Address: 4, FIELD HEAD FARM COURT, SHEPLEY, HUDDERSFIELD, HD8 8FH

Application number: 2026/92089	
What is the application for?:	Erection of single storey detached dwelling and associated access
Address of the site or building:	north of, 5, Field Head Farm Court, Shepley, Huddersfield, HD8 8FH
Postcode:	HD8 8FH

Type of comment: An objection	
Do you wish your comments to be published on the website anonymously?	No
Objection to Planning Application 2026/92089	
I wish to object to the above planning application. I am a Chartered Architect and the occupier of the property immediately adjoining the application site. My principal objection is the loss of openness and the physical and visual intrusion of a new dwelling into what is presently open Green Belt garden land. The submitted elevations also appear to overstate the existing boundary hedge and understate how visible the dwelling would be. Further concerns relate to privacy, loss of sunlight to our garden, the safety of the proposed access, and the impact on the established hedgerow. Green Belt, openness and visual impact The site forms part of the open garden behind the established properties at Field Head Farm Court and extends t

Proposed Block Plan

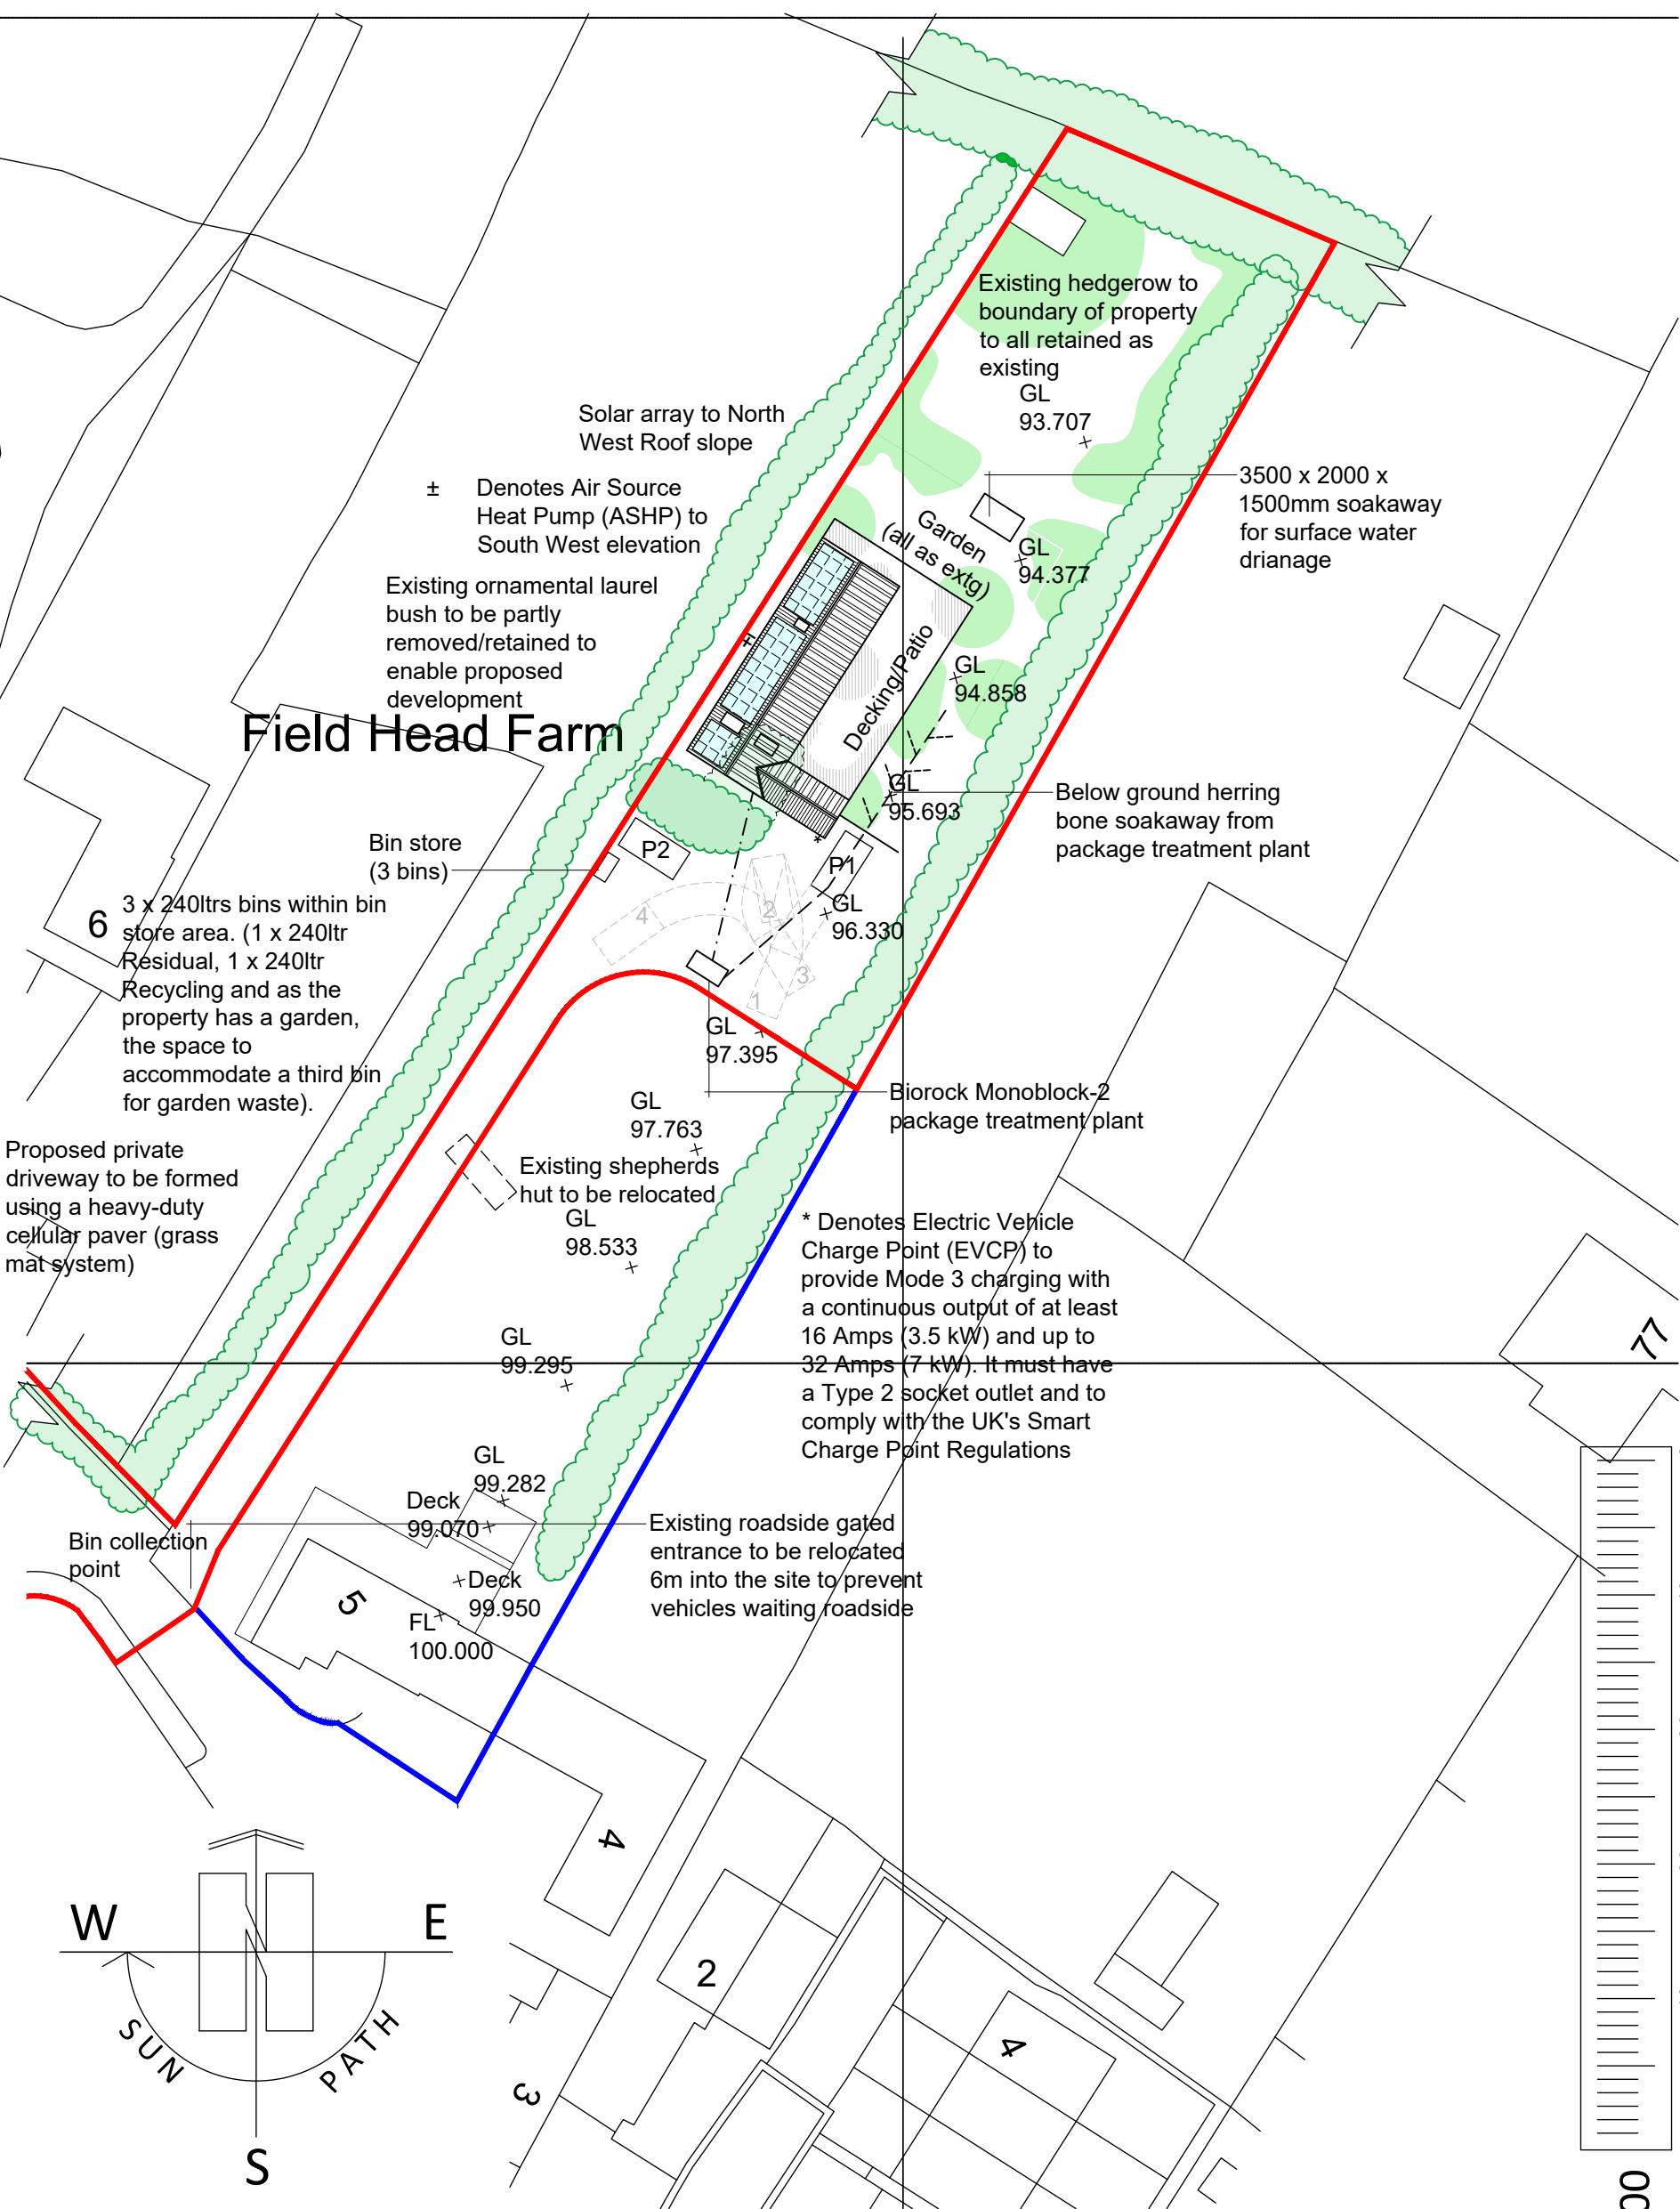
The submitted drawing shows the area around the proposed entrance as an unobstructed manoeuvring space. This is not representative of the Court in normal use. The application should show the existing parking arrangements and demonstrate how vehicles would enter, leave and manoeuvre when these areas are occupied.
